Engineers Comments Regarding Surface Water Drainage

Application Reference:	BN/24/26/DOC	Reviewer Reference:	ADC/EXT2/94
Planning Officer:	Amber Willard	Date of Review:	26/03/2026
Site Name:	Land South Of Wandleys Lane Eastergate PO20 3SE		
Application Description:	Approval of details reserved by condition under BN/46/25/PL relating to conditions 4- Surface Water Drainage and 5- Foul Water Scheme.		
Assessment Number:	1 of 2

Permeable Paving 2 at PS5-DIF (100Yr+45% 120Min Summer)

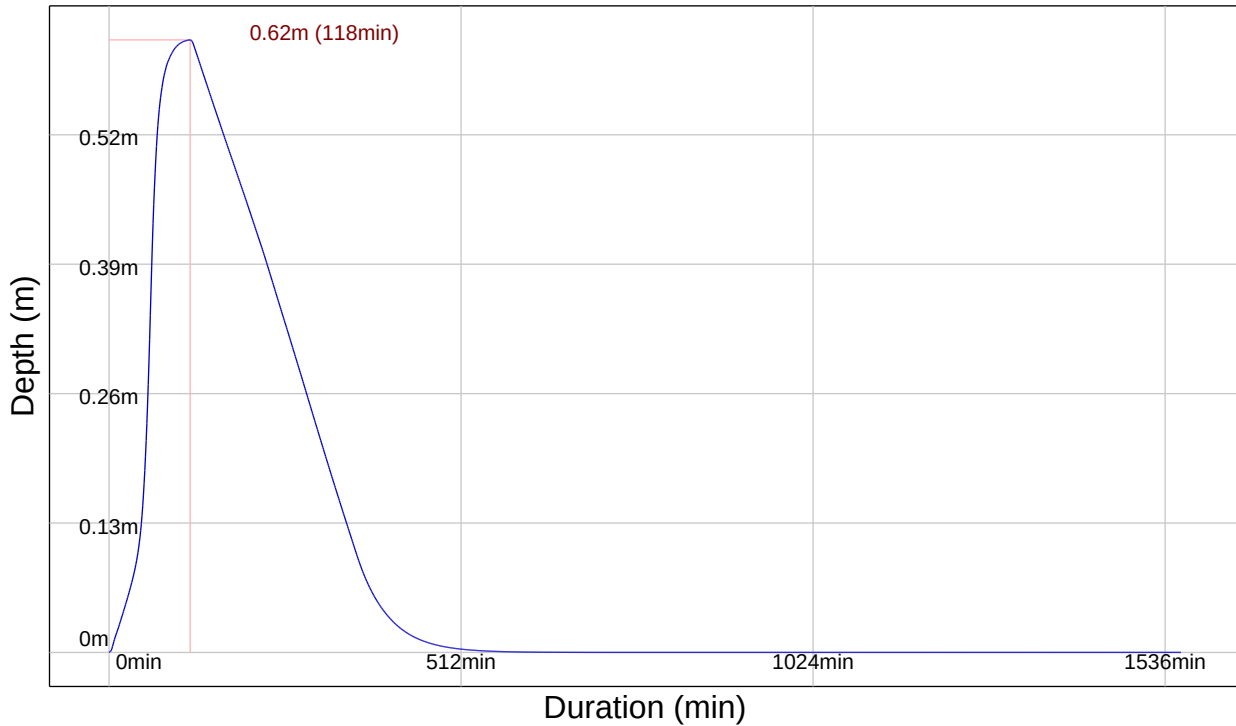
23.	Show the connection from the channel drain adjance to PS5-DIF (must pass through catchpit)				
24.	Provide a detail and specification for the root barriers and demonstrate that proposed pipework is adequately protected (eg run between PS3 and PS5-DIF).

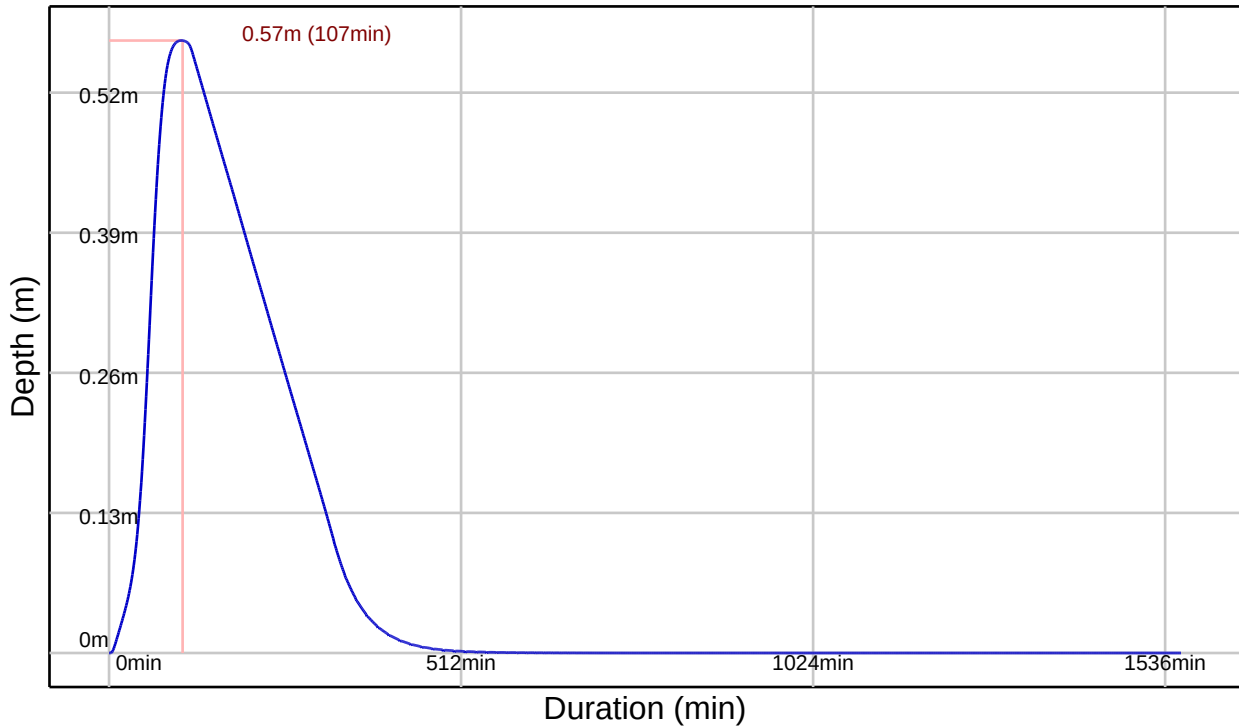
9.	The calculations for Permeable Paving 3 appear to be based on a 1.2m deep sub base but the plans states 0.675m. Ensure the drawings and calculations are consistent.
